Subject: RE: 23452 Stakers Farm, Yapton - Y/52/22/DOC Designers Response

Further to LLFA Response dated 20 September 2022 for information on the Discharge of Condition application Y/52/22/DOC, we have attached updated drainage drawing 201A_Proposed Drainage Plan together with revised calculations and construction details based on the comments received.

Engineers Comments Regarding Surface Water Drainage

MANHOLE WITH HYDROBRAKE
(Scale 1:25)

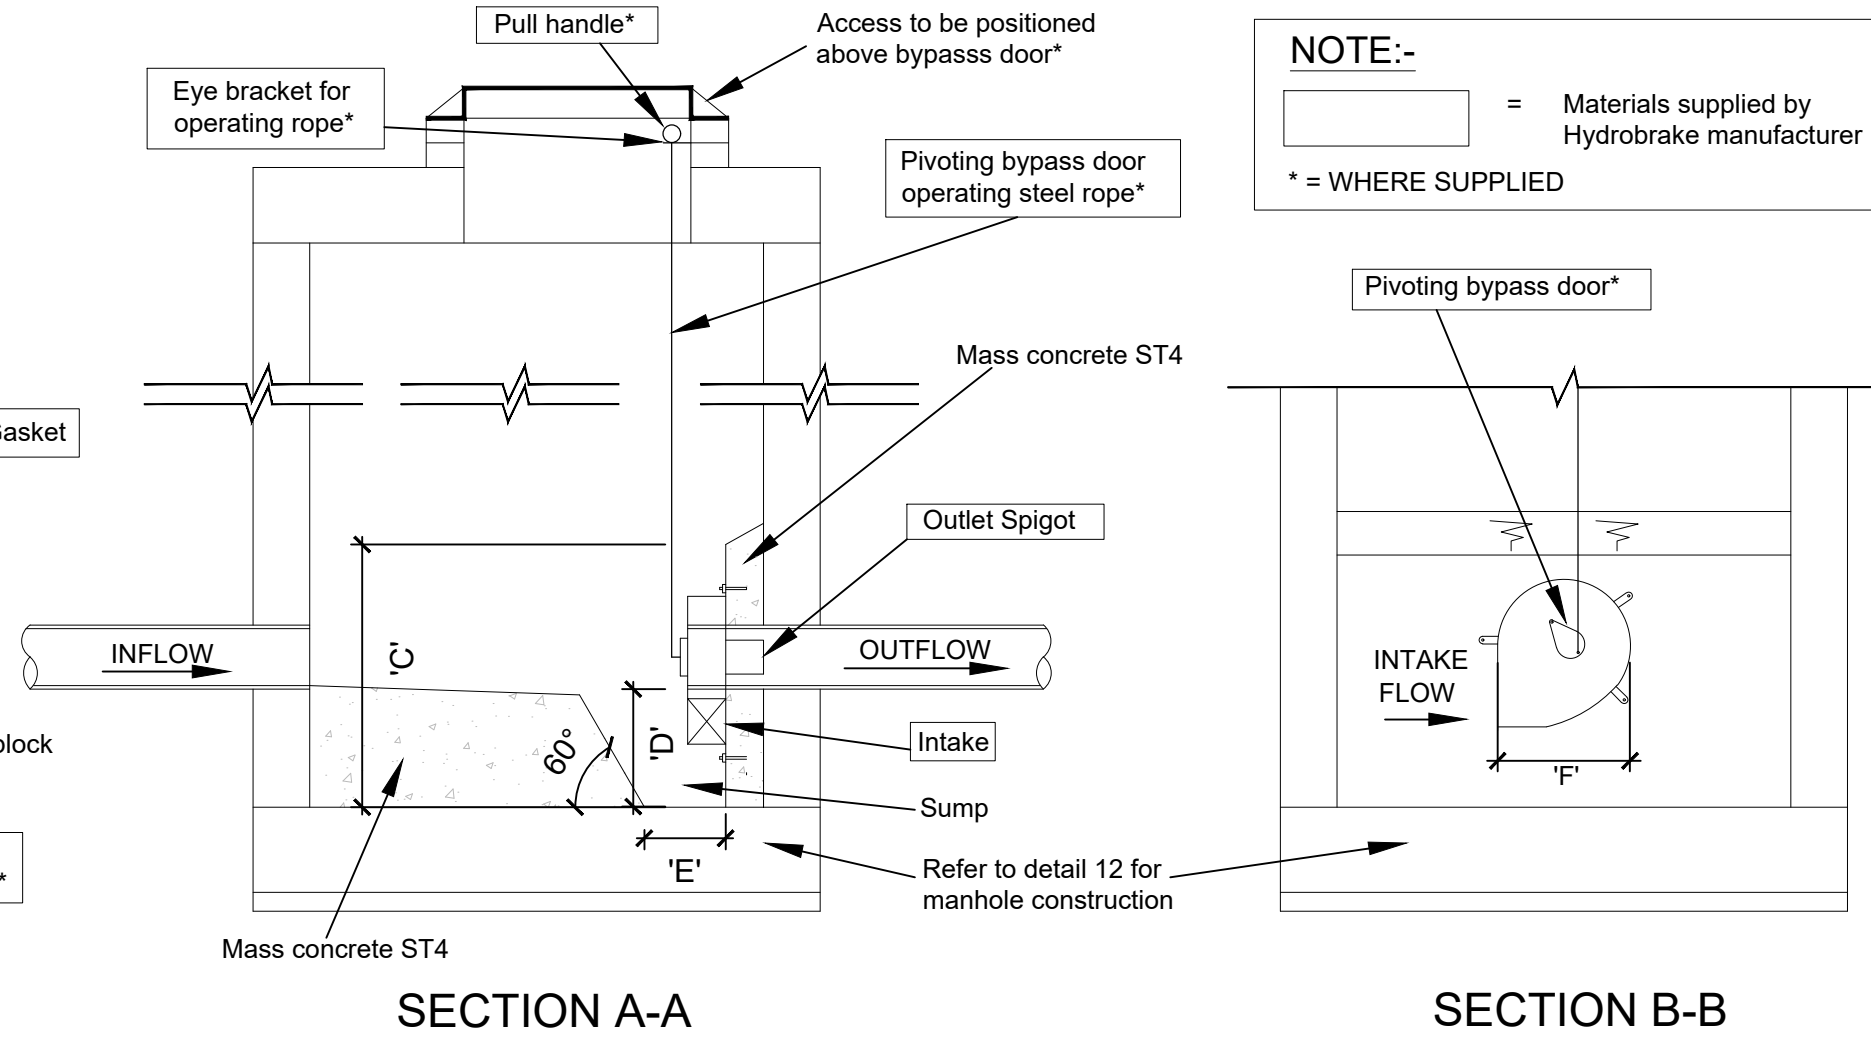
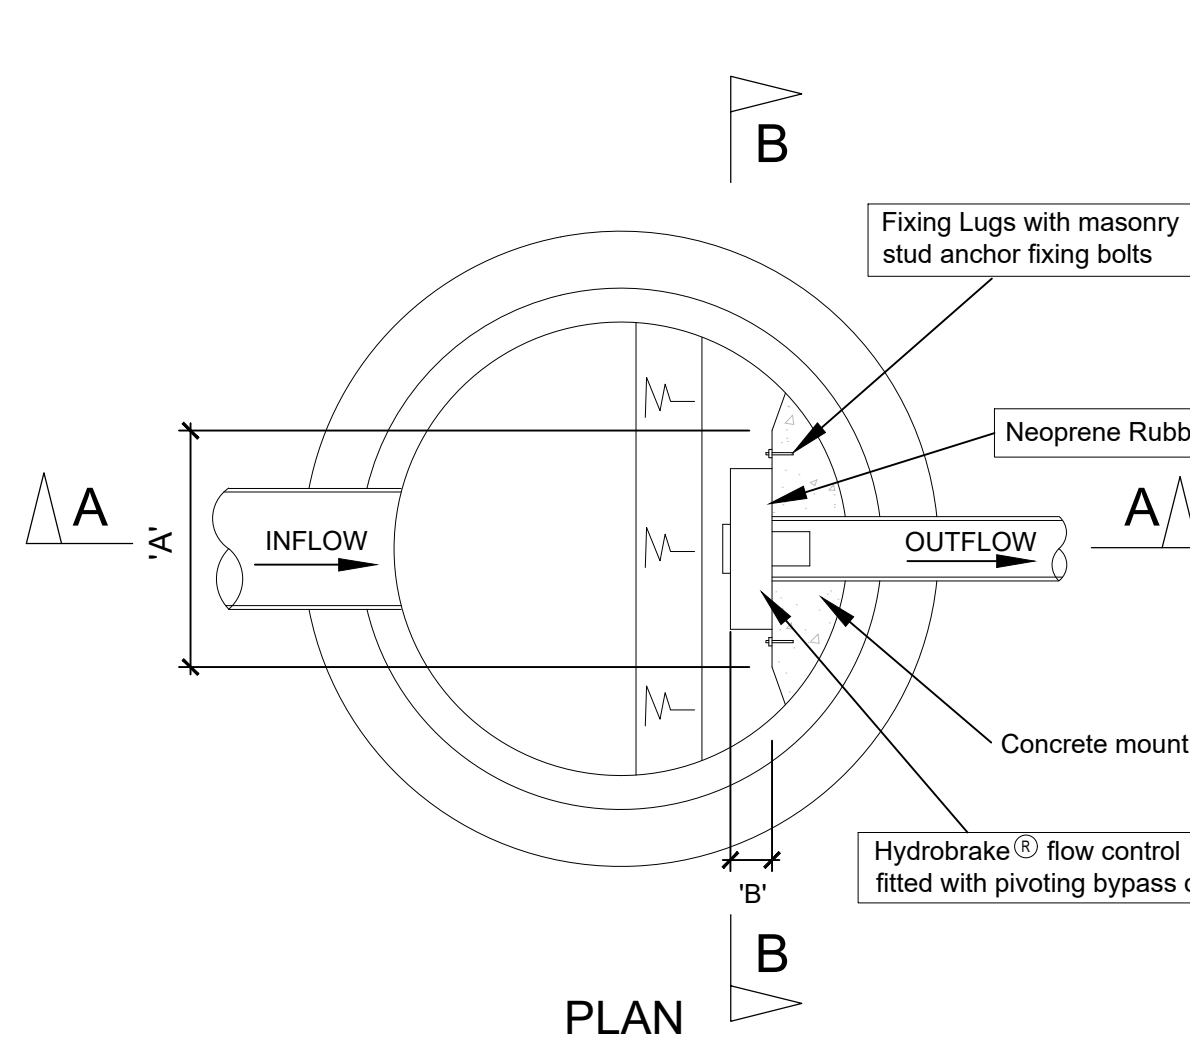
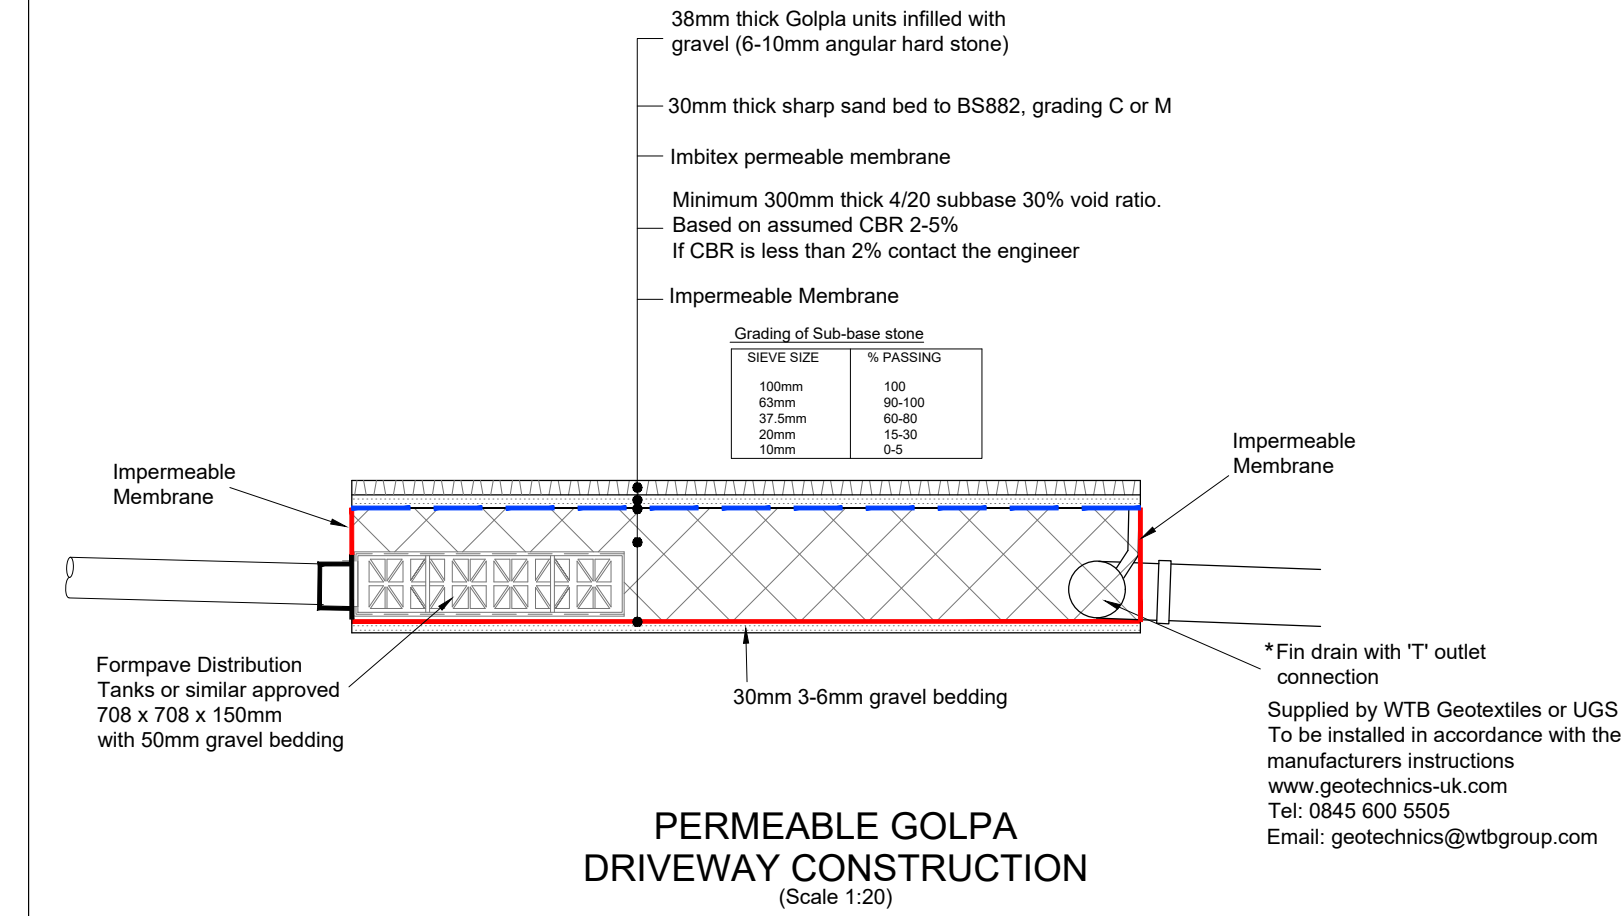
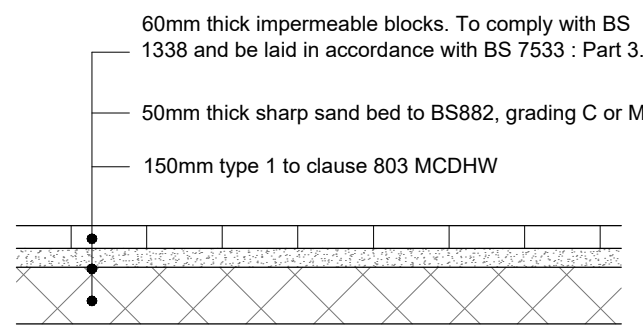
- The Hydro-Brake manhole is deeper than 1m, building regulations recommends manholes of this depth to have rungs or a ladder, which is not shown on the cross-section drawing. Justification for why this has not been shown should be provided, or the drawings updated accordingly. Construction details have been updated, hydrobrakes are proposed at less than 1m in depth, please see drawings 501B_Proposed Construction Details and 201A_Proposed Drainage Plan
